**CITY OF ALBUQUERQUE  
PLANNING DEPARTMENT  
October 4, 2006  
DRB Comments**

**RE: Lots 12A & 13A, Block 20, Parkland Hills Addition/sketch**

DEVELOPMENT REVIEW BOARD – SPEED MEMO

**DRB CASE NO/PROJECT NO: 1005168**

**PLAT OF
LOTS 12-A AND 13-A, BLOCK 20
PARKLAND HILLS**

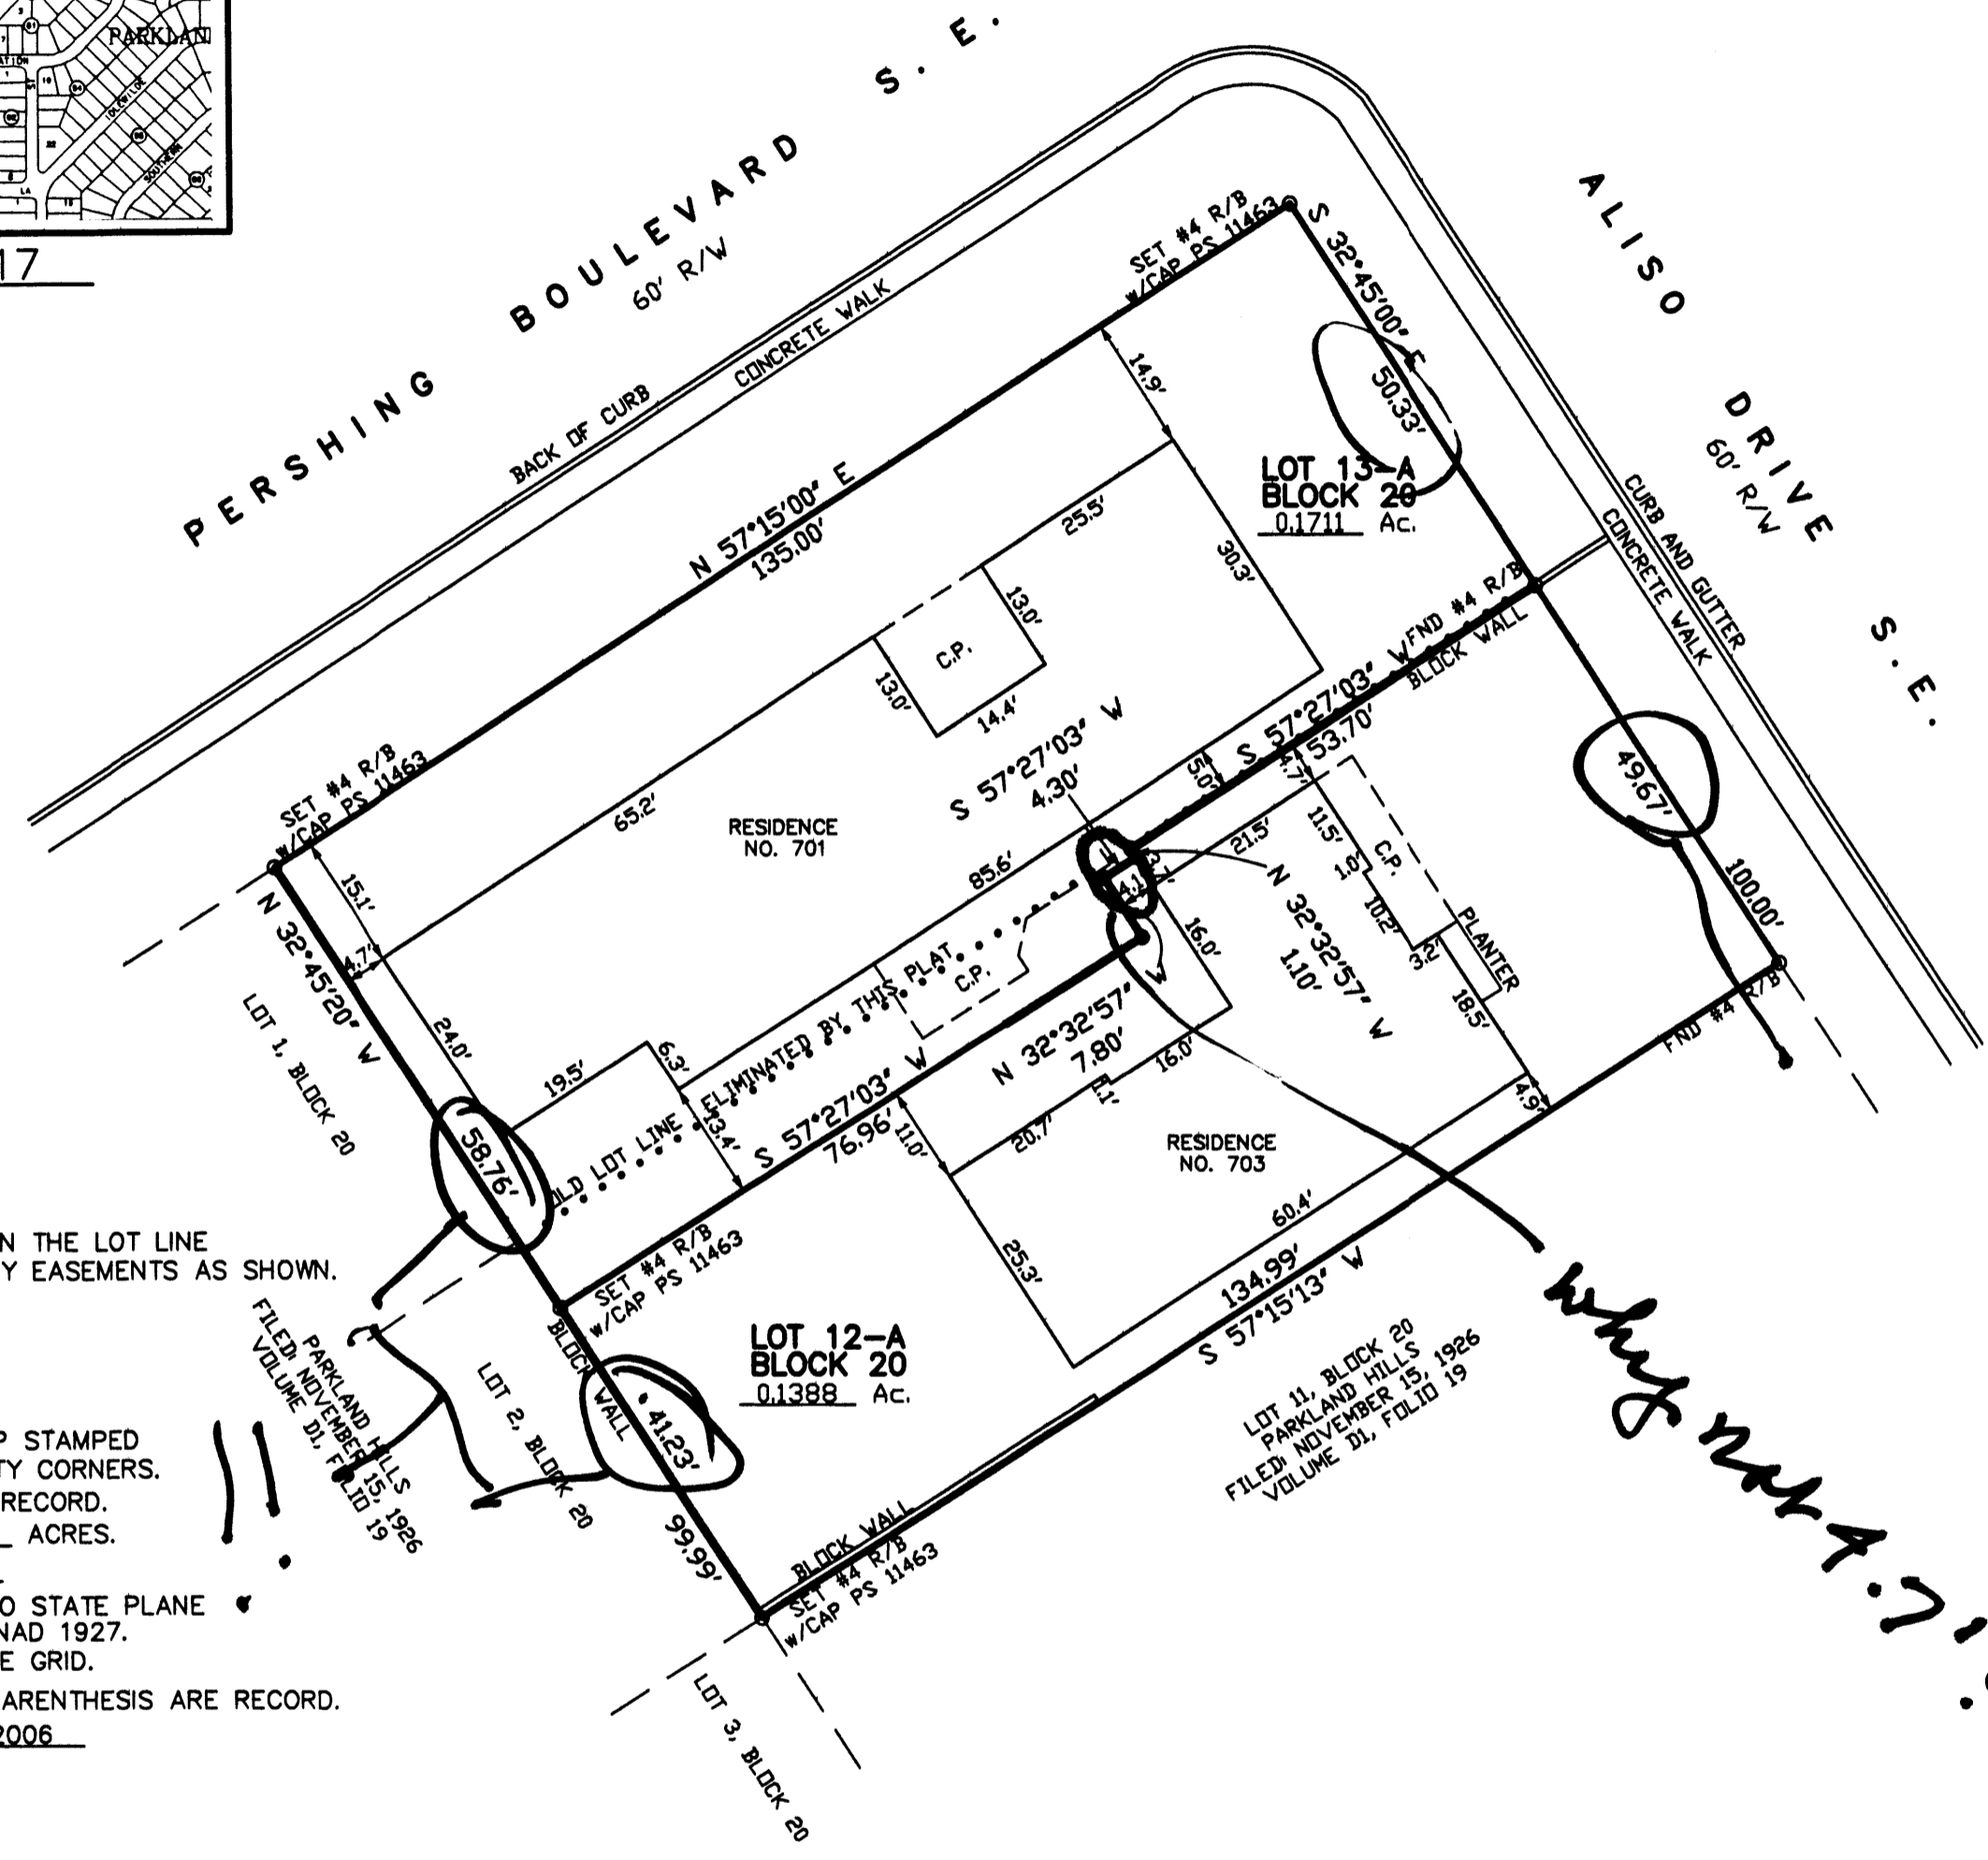
By splitting the lots, it does not appear that the lots meet the side yard setback requirements of 5 feet.

Before the proposed lot line adjustment the lots came much closer to meeting the required 50' lot line minimum size that this proposed replat. The replat has shown significantly reduces the minimum lot size for Lot 12.
